NORTH FALLS OFFSHORE WIND FARM DEVELOPMENT CONSENT ORDER

PINS REFERENCE EN010119

**DEADLINE 5: PORT OF LONDON
AUTHORITY'S COMMENTS ON SUBMISSIONS
RECEIVED AT DEADLINE 4**

Deep Water Route Cable Installation Areas (Future Dredging Depths) Plan

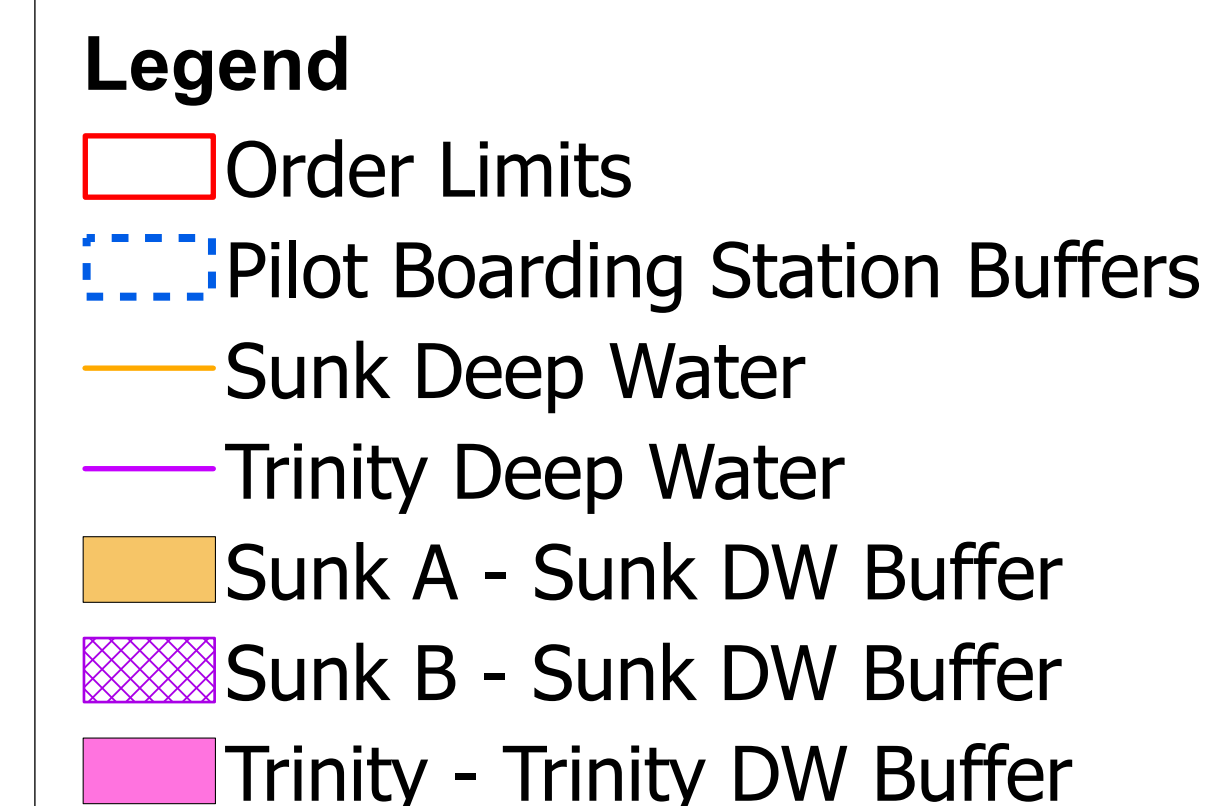
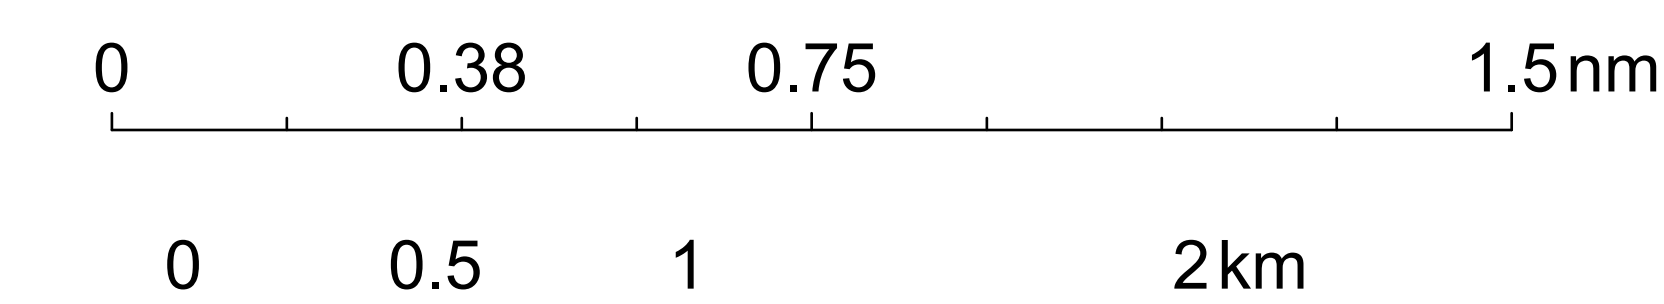
2.1 The PLA welcomes the general approach that the Applicant took to the Deep Water Routes ("**DWRs**") future dredging depths, continuing the Sunk DWR seaward on the same basis as the Five Estuaries Offshore Wind Farm ("**VEOWF**") i.e 1km width at - 22m Chart Datum ("**CD**") and an additional 200m each side at -19m CD. However, given the location of the North Falls red line boundary the Applicant's proposed approach would leave areas at the top of the Trinity/Sunk diamond which are not subject to the deeper cable installation/maintenance requirement. The image on the next page shows the North Falls red line boundary for the order limits in red, the VEOWF order limits in grey, the combined areas subject to requirement in orange and the extension of the Sunk DWR and additional areas that need to be included in green. The area in grey relates to VEOWF and that area is already deep. The majority of the green area will need to allow for dredging to -22m CD and the PLA could otherwise accept the 200m buffer to the south at -19m CD.

2.2 The PLA has provided the Applicant with its comments on the Deep Water Route Plan [REP4-043] and awaits a response. Once agreement has been reached on the extent of the area required for deeper cable burial, plans and documents (including the outline Navigation and Installation Plan ("**oNIP**") and outline Sediment Disposal Management Plan ("**oSDMP**")) will need updating accordingly.
